Arun District Conservation Area Advisory Panel  
c/o Civic Centre

Application No: AB/127/20/L  
Site Address: Bay Tree House 16 Tarrant Street Arundel BN18 9DJ  
Description of works: Listed building consent for satellite dish to internal valley, retention of existing neighbour's TV aerial & removal of redundant tv aerial to east chimney.

PROPOSED ROOF PLAN

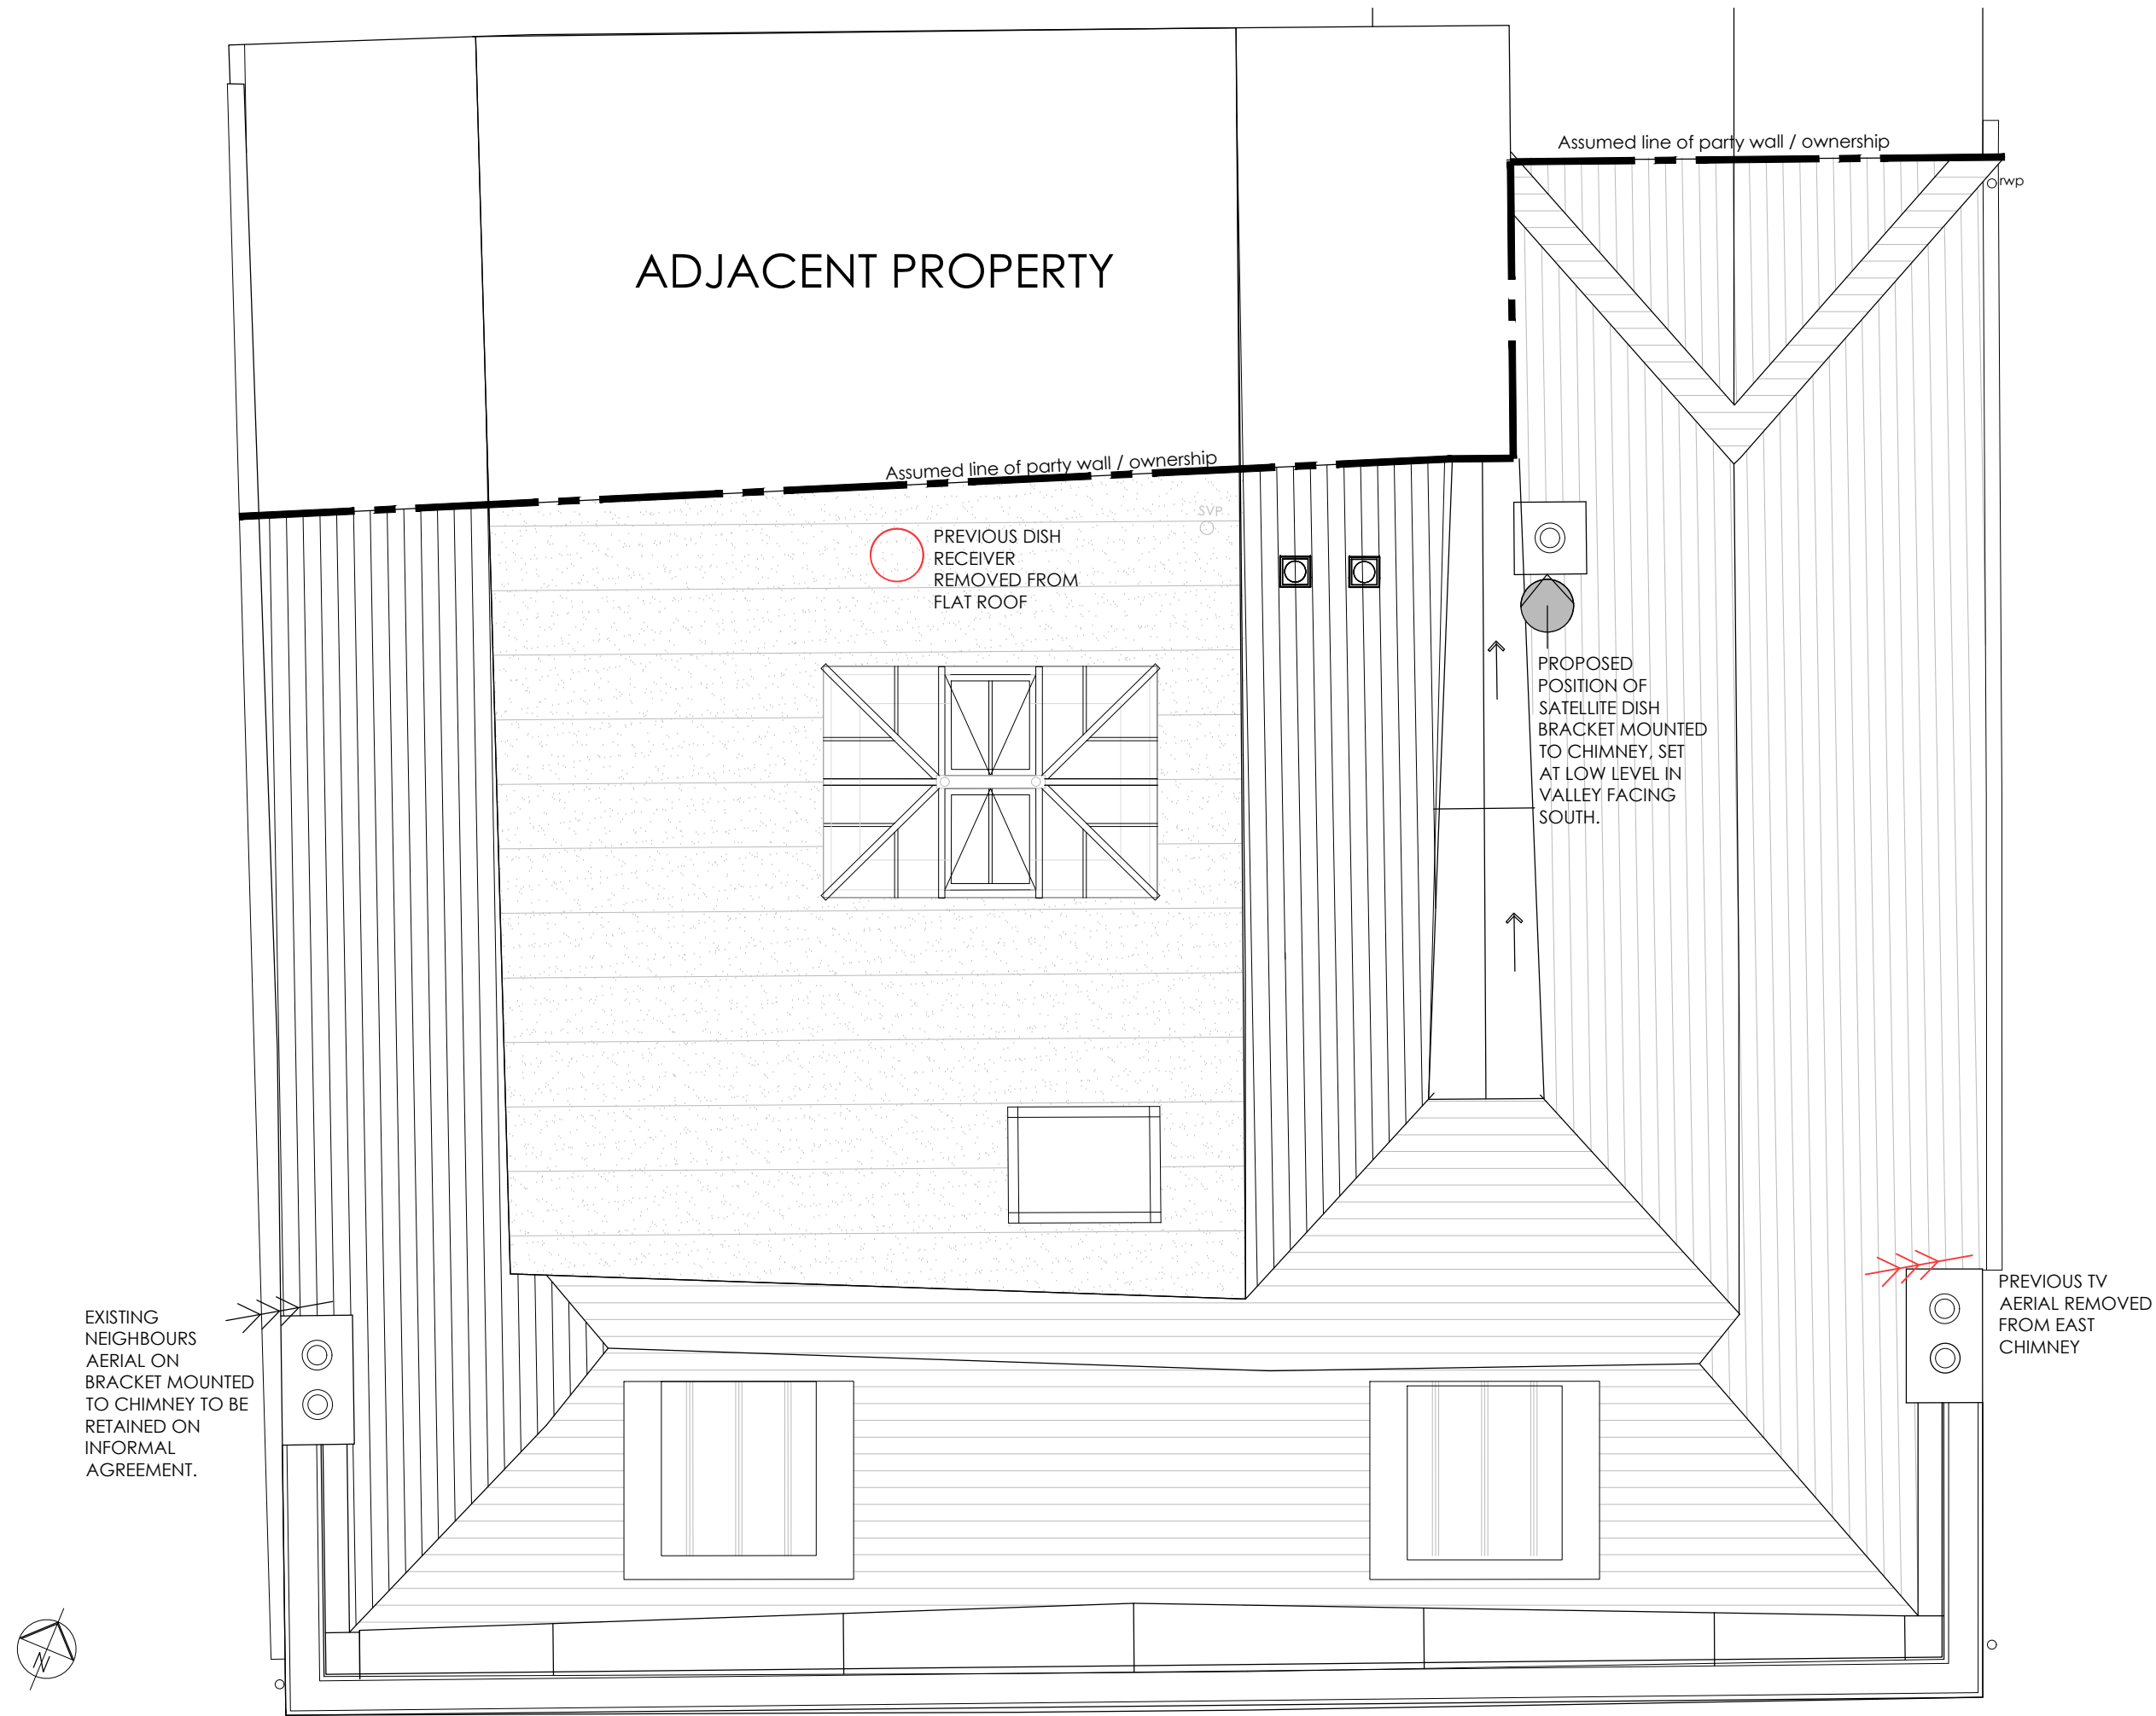
The proposal to reduce the clutter of antennas on this important historic building is welcomed. It may be appropriate to establish what the height of the satellite dish will be above the valley floor although from the information shown on the plans it is most unlikely that it will be seen from public views. There will be no harm to the character or appearance of the conservation area.
